I wish to comment on the Yew Tree Farm proposed development including the related applications 2021/65/93007/E listed building consent and 2021/65/92969/E demolition of agricultural buildings.

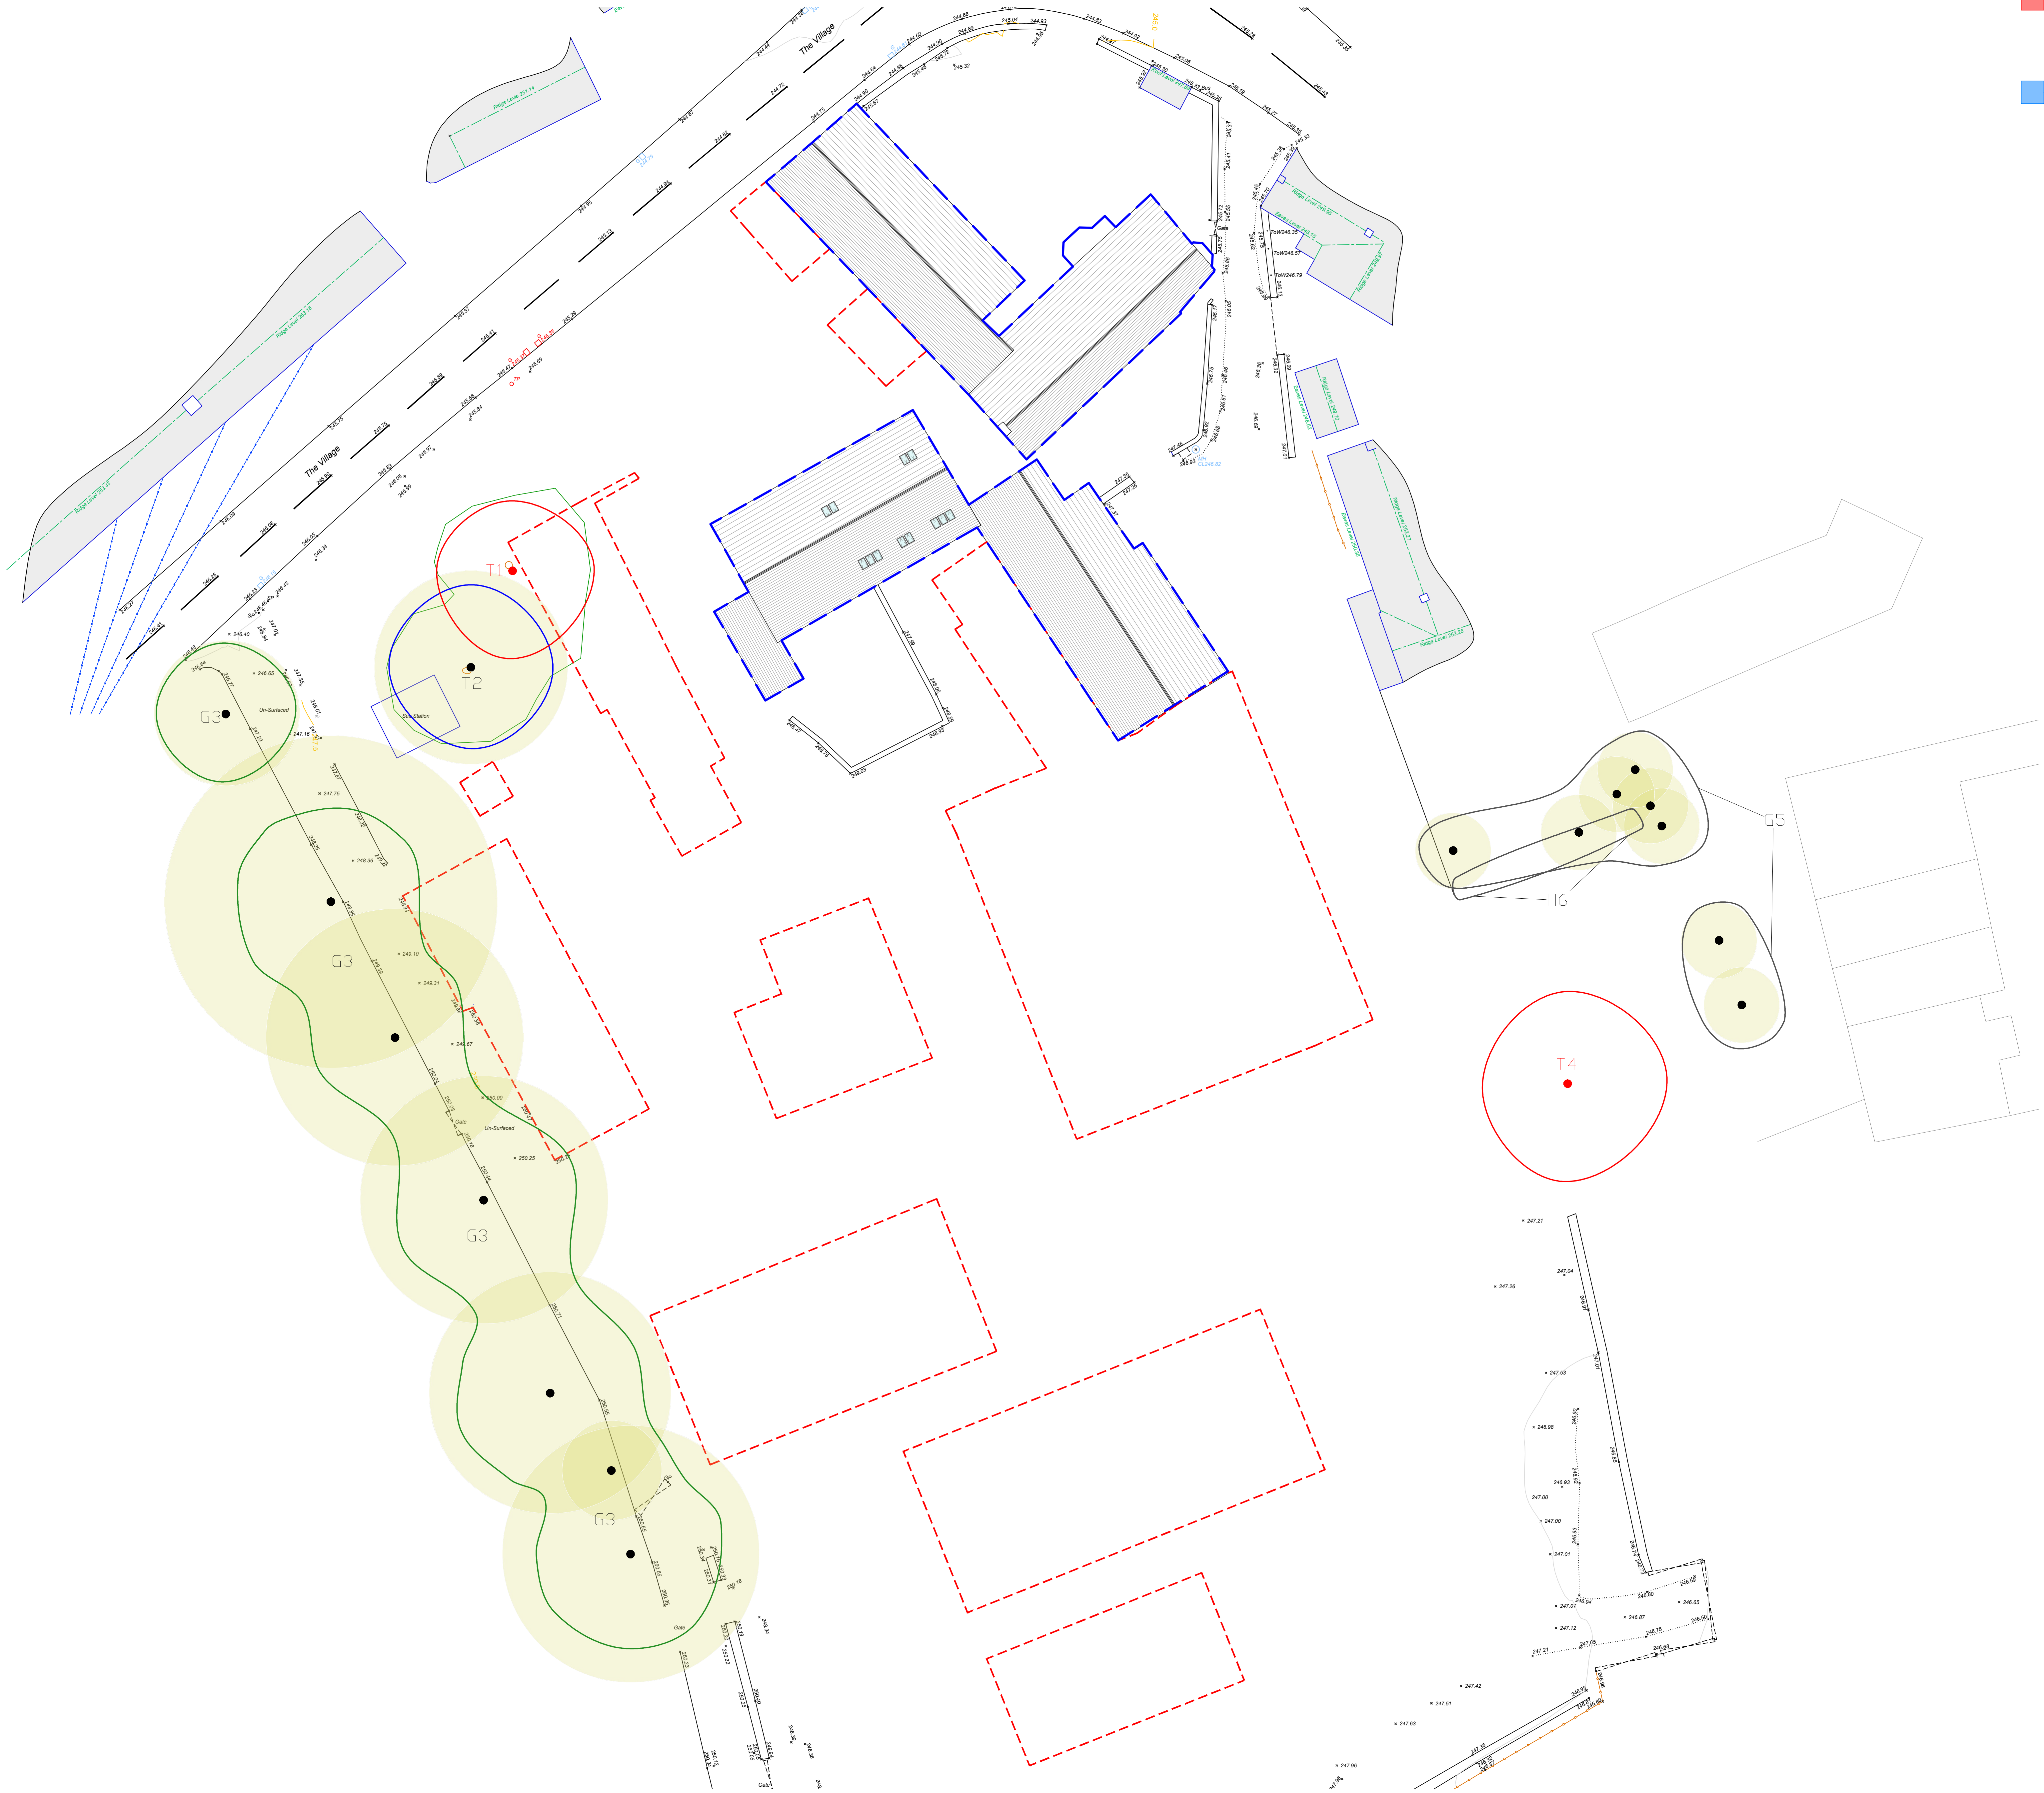
The removal of two very significant trees of over 100 years to create a new entrance to the site and to allow an extra house on the southern boundary should not be allowed.

PROJECT TITLE YEW TREE FARM			
DRAWING TITLE THE VILLAGE SECTION			
SCALE 1:100	DRAWN JH	CHECKED JH	PROJECT REFERENCE ODS_20/294
PAPER SIZE A3	DWG NUMBER (72)003	DATE 25/3/21	REVISION /
CLIENT RADCLIFFE DEVELOPMENTS (FARNLEY)

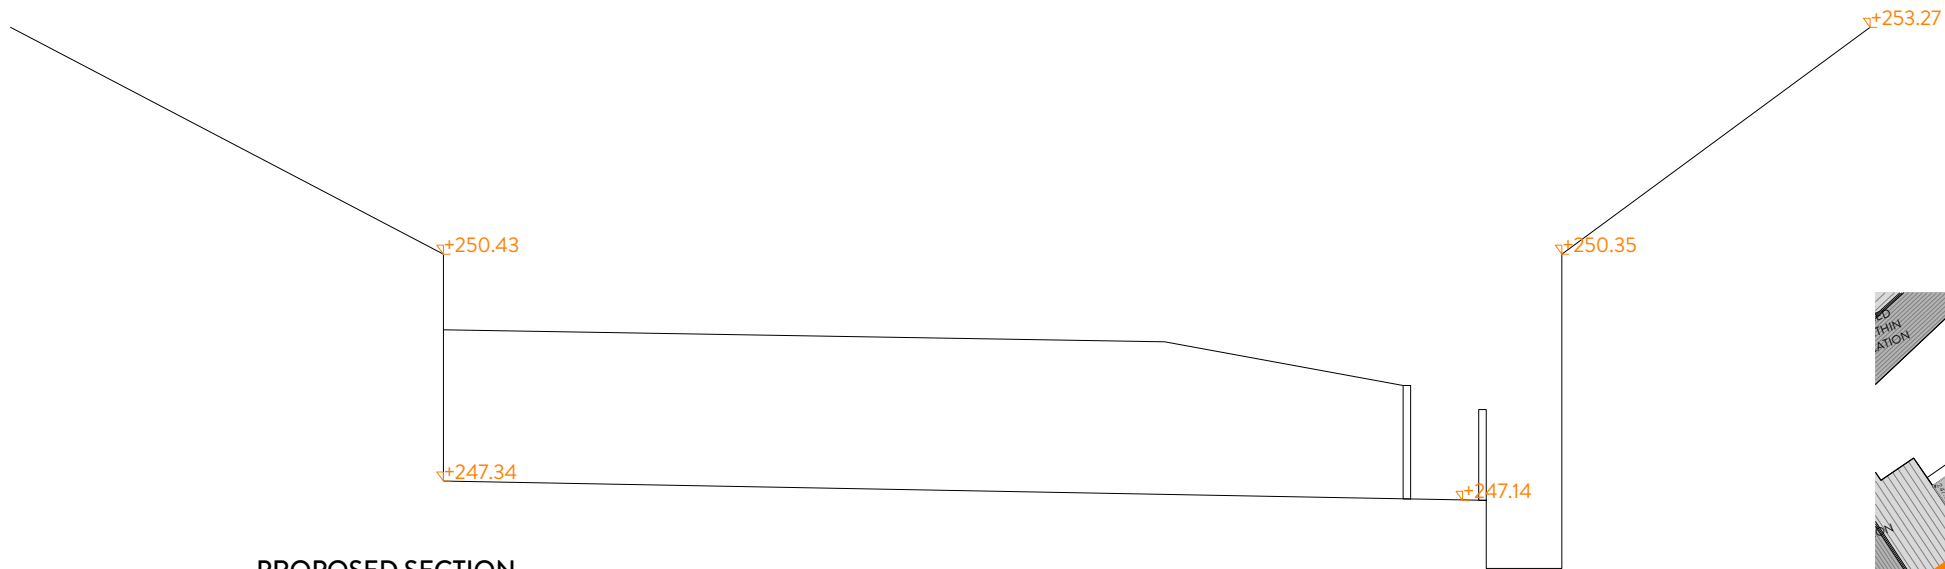
The proposed car parking off The Village will dominate the centre of the village. The coming and going of vehicles into a very tight parking space will be problematic and the headlights will cause huge light nuisance to the occupiers of all adjacent houses. Parking seems only sufficient for one vehicle per household with no provision for visitors. Car parking on the The Village is already full and creates a hazard when entering the village from Honley Rd.
